Odour Assessment Review
Land at Ford Airfield, Ford,
West Sussex
February 2022

Review of Odour Assessment

Land at Ford Airfield, Ford, West Sussex

Project no.	Project
8693C	Odour Assessment Review: Land at Ford Airfield, Ford, West Sussex

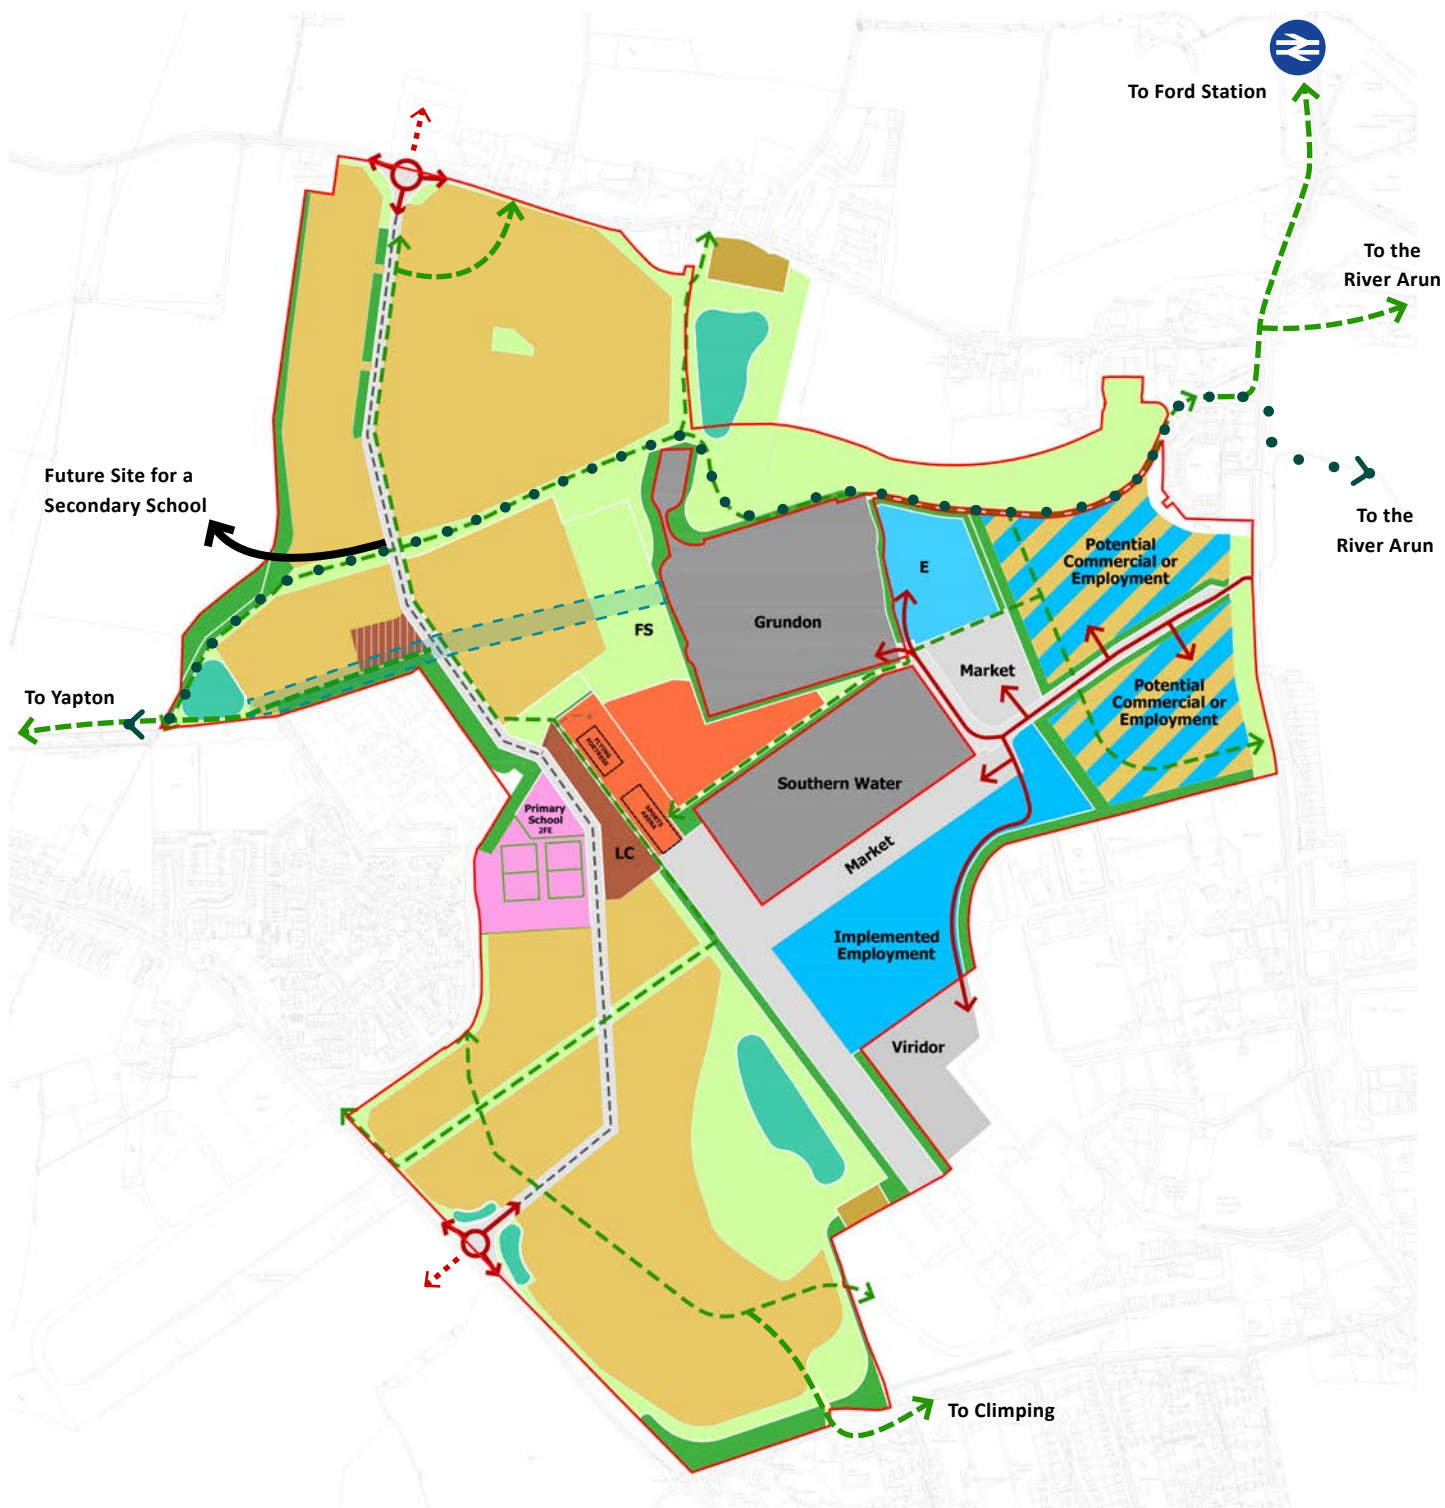
- 1.12 No sniff tests were undertaken by Hoare Lea in the area of proposed residential units that are considered most at risk of odour nuisance, due to access (See Figure 1 below). These are those units that are, at their closest point, approximately 100m from the WwTW, to its west.

- 1.13 The absence of observational data at the most at risk part of the proposed development is concerning and does not provide a weight of evidence in support of the conclusions drawn. However, it is noted that this was, in part, due to access limitations for odour surveys (although it is not understood why the applicant did not have rights of access to the land it is proposing to develop).

- 1.35 It is understood that the shape of the parkland to the southern half of the proposed development is principally based on the shape of the odour contours from Hoare Lea's modelling. This illustrates the high degree of confidence that the applicant has placed on the results of odour dispersion modelling, while disregarding the conflicting results of sniff tests and other assessment tools. The outline design of the proposed development has thus excluded residential units up to 500m from the WwTW's southern boundary, while including them much closer, within 100m, of its western boundary. Due to the uncertainties of the modelling assessment, the poor agreement of model results with sniff tests, the limitations of when and where the sniff tests were carried out, and the vagueness of the complaints records, this focus and reliance on the dispersion model seems weakly founded.

- 1.37 In essence, there remains a discrepancy between odour modelling (which, on its own, is recognised to be an inherently inaccurate tool) and onsite observations. This discrepancy has not been explained such that the model results could be considered robust. As such, until or unless work is done to provide observational data that better fit the model, it is recommended that the precautionary principle is applied. This means that it should be considered likely that unacceptable odours will affect the proposed residential units within 300m of the aerated sludge plant to the west of the WwTW.

- 1.34 We recommend that further sniff tests are carried out to cover the most 'at risk' locations and under a wider range of environmental conditions in order to properly test the reasonableness of Hoare Lea's modelling results.
